DEVELOPMENT FACILITATIVE TEAM (DFT)
HEARING OCTOBER 2, 2024
UPDATE: 06/05/2024 Application Submittal

Project Number PR-2024-010446
SI-2024-00774-SITE PLAN DFT

RE: Site Plan Amendment for new construction

APPLICANT RESPONSES TO THE STAFF COMMENTS:

3 SW1 DUMPSTER ENCLOSURE PLAN AND DETAILS

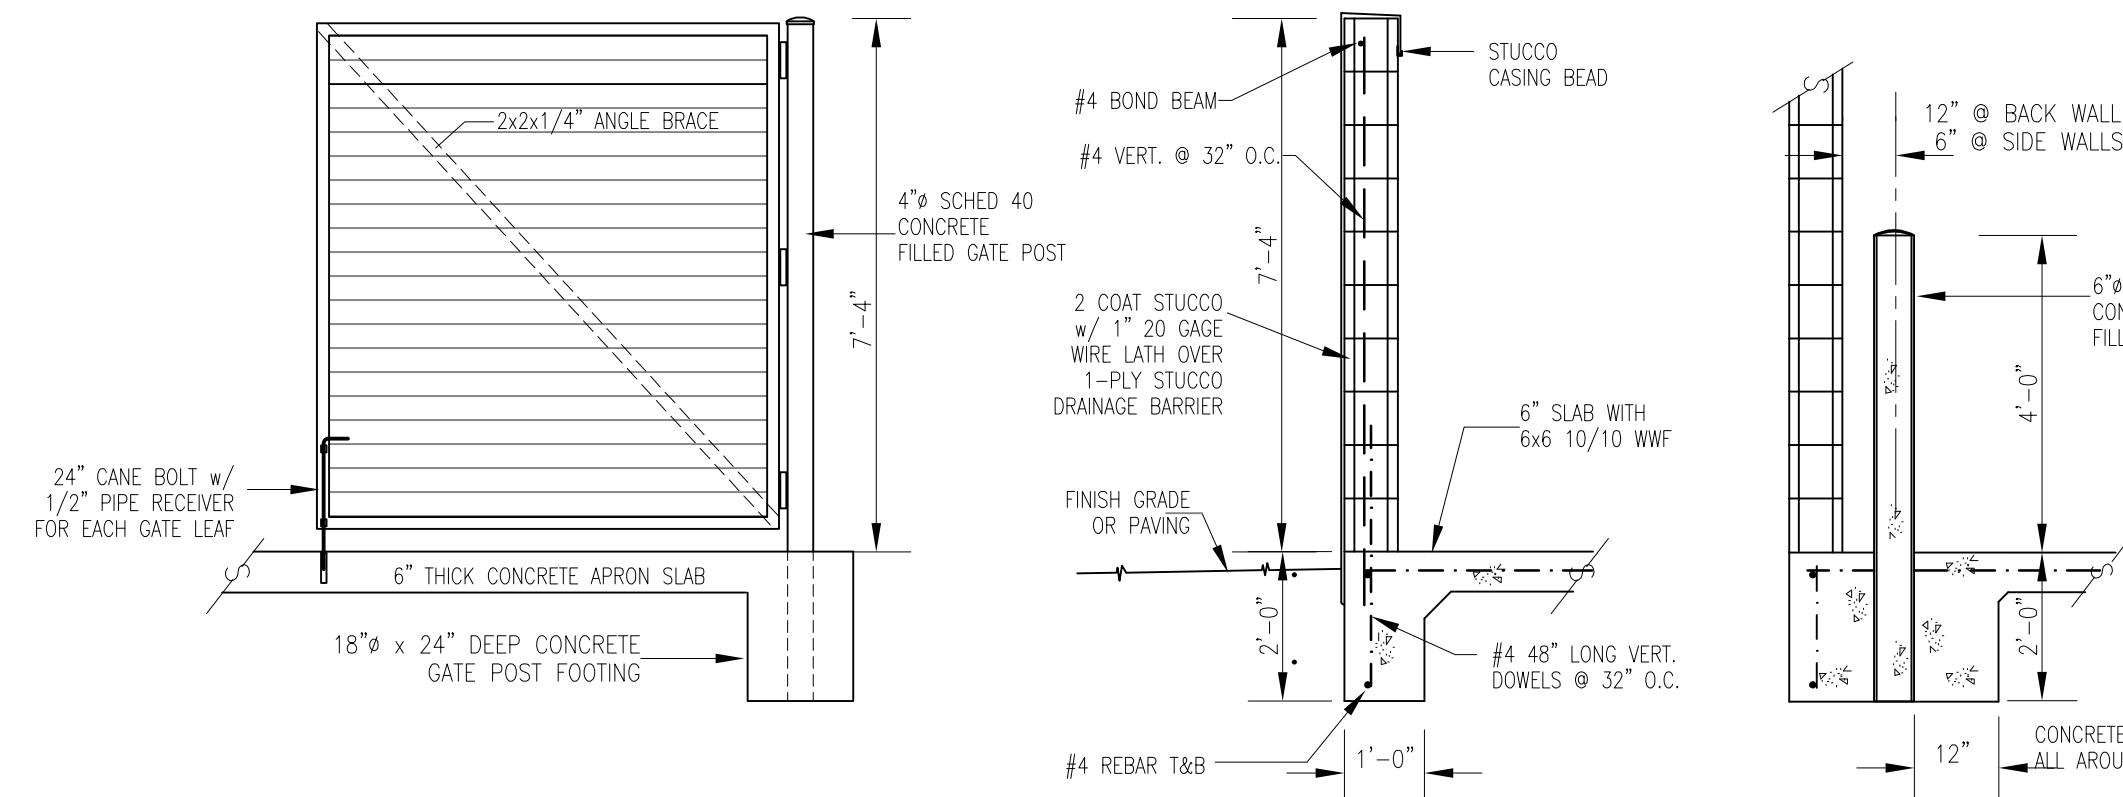
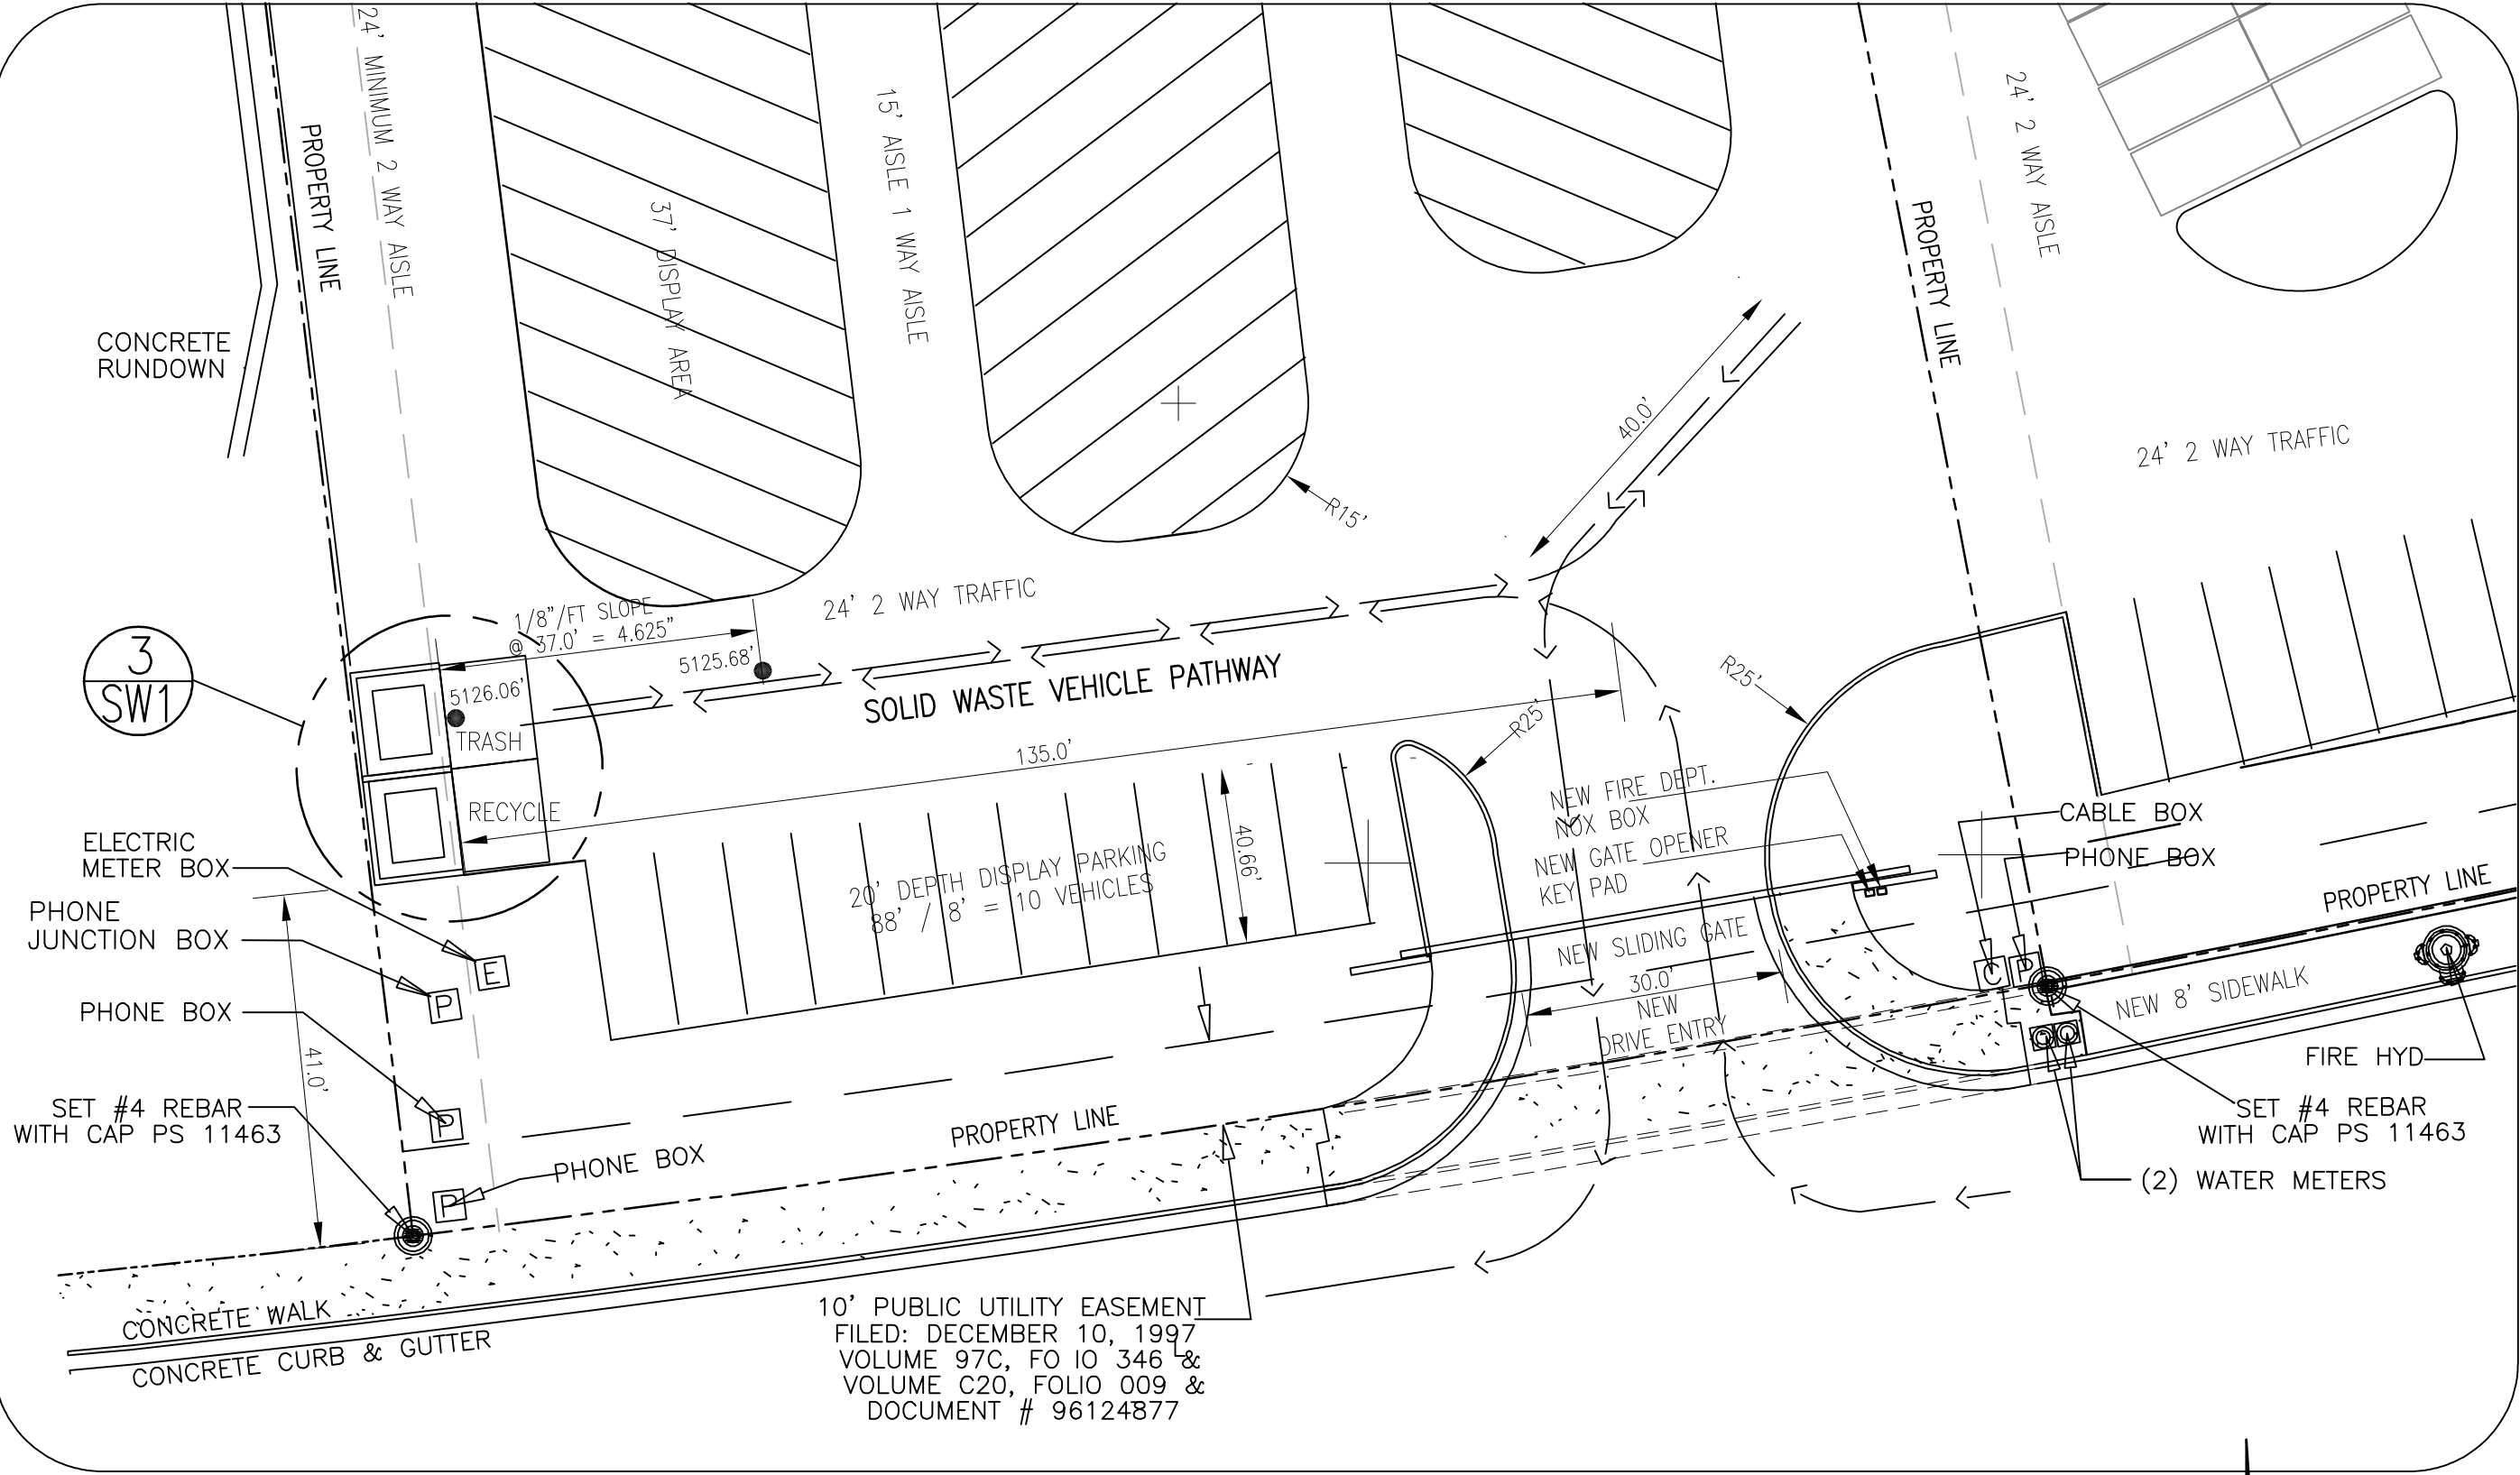
Outdoor loading, service, and refuse areas shall be integrated into the building design if possible, or shall be located where they are not visible from streets, City parks, Major Public Open Space, trails, or major arroyos adjacent to the lot or from adjacent properties with low-density residential development to the maximum extent practicable.

SOLID WASTE REFUSE CONTAINERS ARE SCREENED FROM PUBLIC VIEW BY STUCCO FINISHED WALLS 7'-4" IN HEIGHT

Drawing file: 2-24-2025 / A1-OFFICE PLANS & ELEVS.pdf

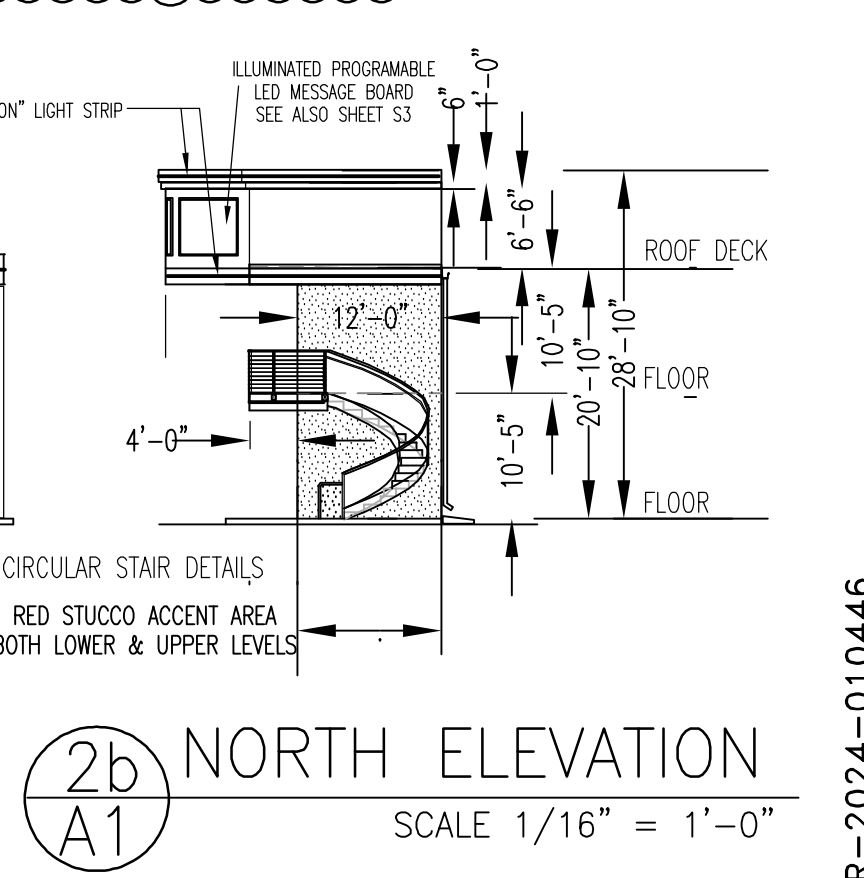
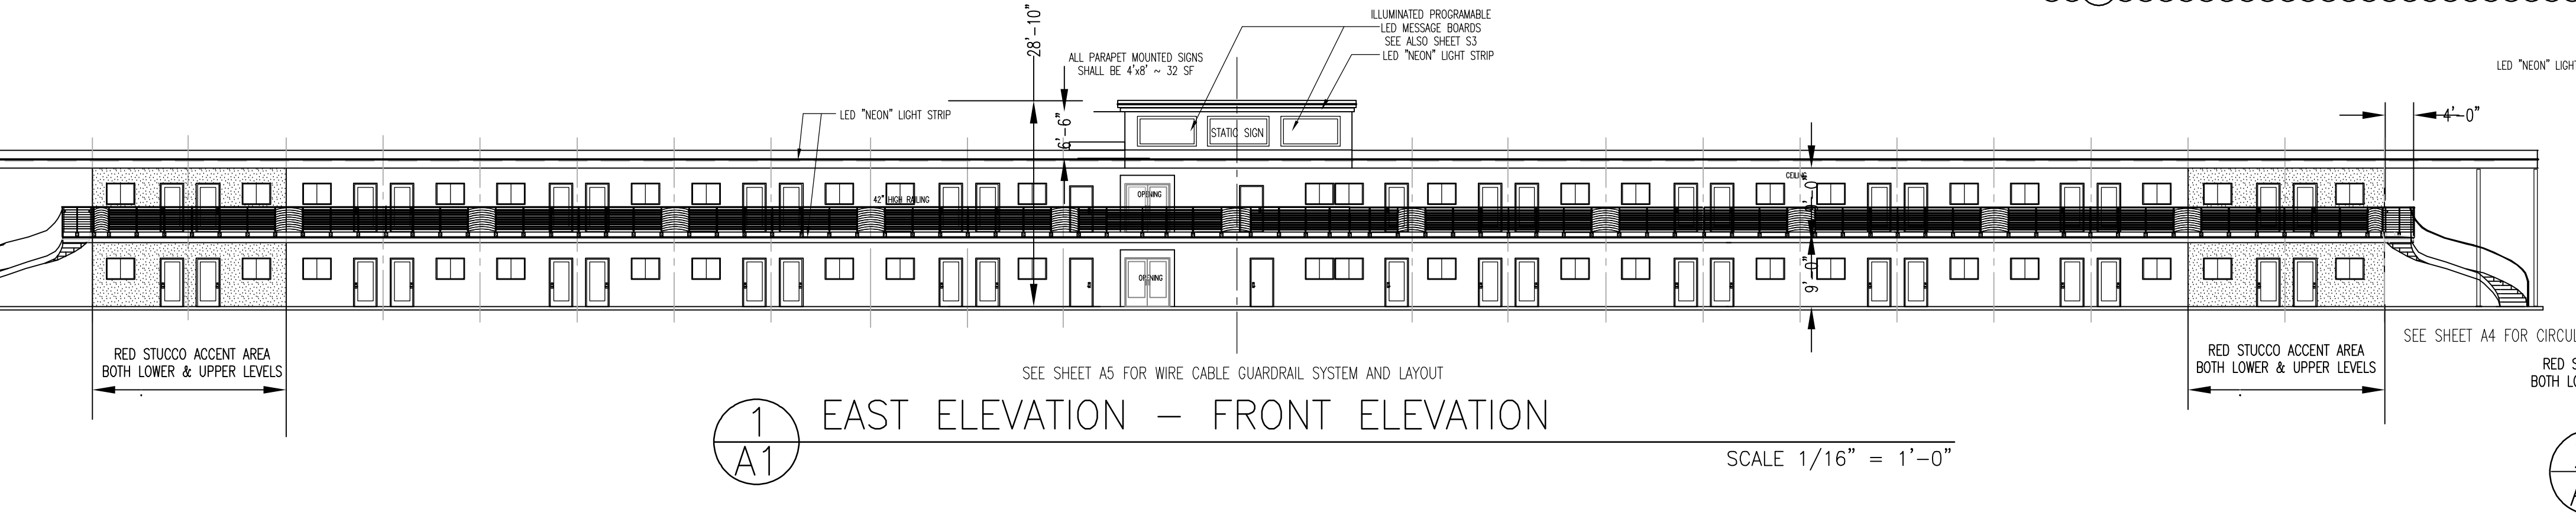
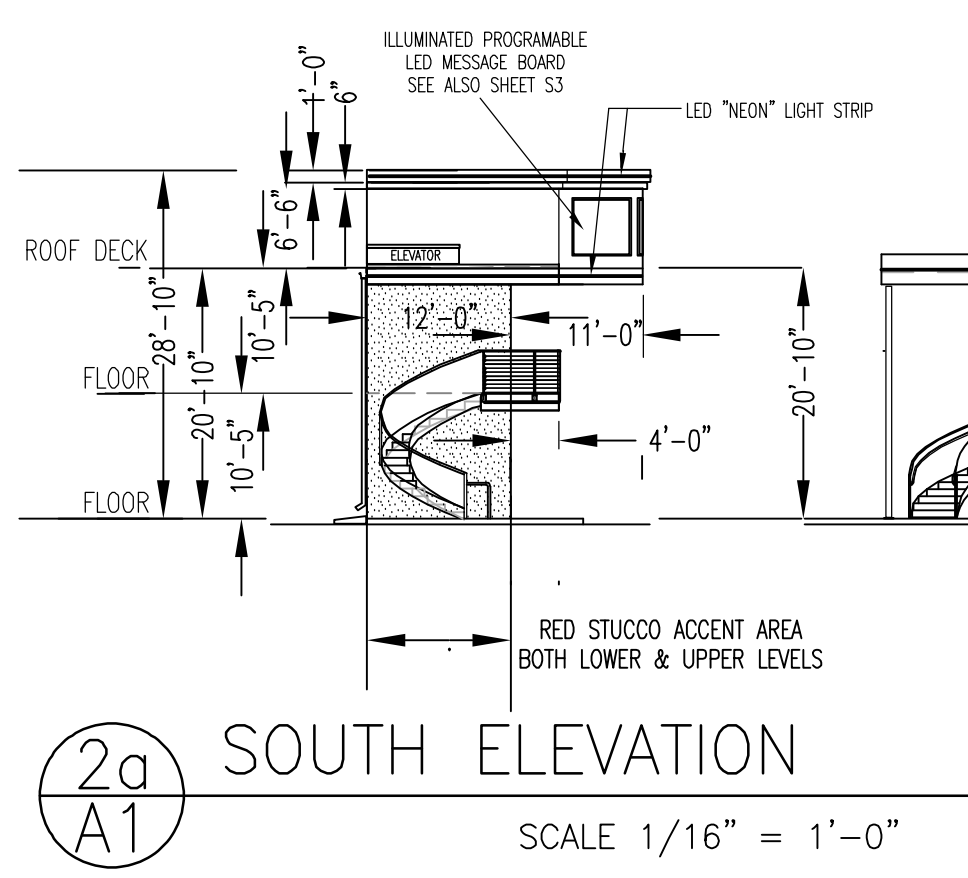
See drawings AC1 Site Layout Plan, A2 Office Building Elevations and A6 Shop Building Elevations.
- As a part of the elevation pages: Provide detail to demonstrate and explain compliance with all sections within 5-11-E and 5-11-E-2. Include detail regarding how the façade and colors will meet the Clifford plan design requirements.

The Office Building as shown on Sheet A1 has a distinct form reminiscent of the Route 66 automobile dealership and service station motif. A broad horizontal conformation and projecting canopy reflects this mid-century ambiance which in this design is accentuated with decorative staircases and varying paint colors.
- The project and application numbers must be added to the Site Plan and any associated IL.
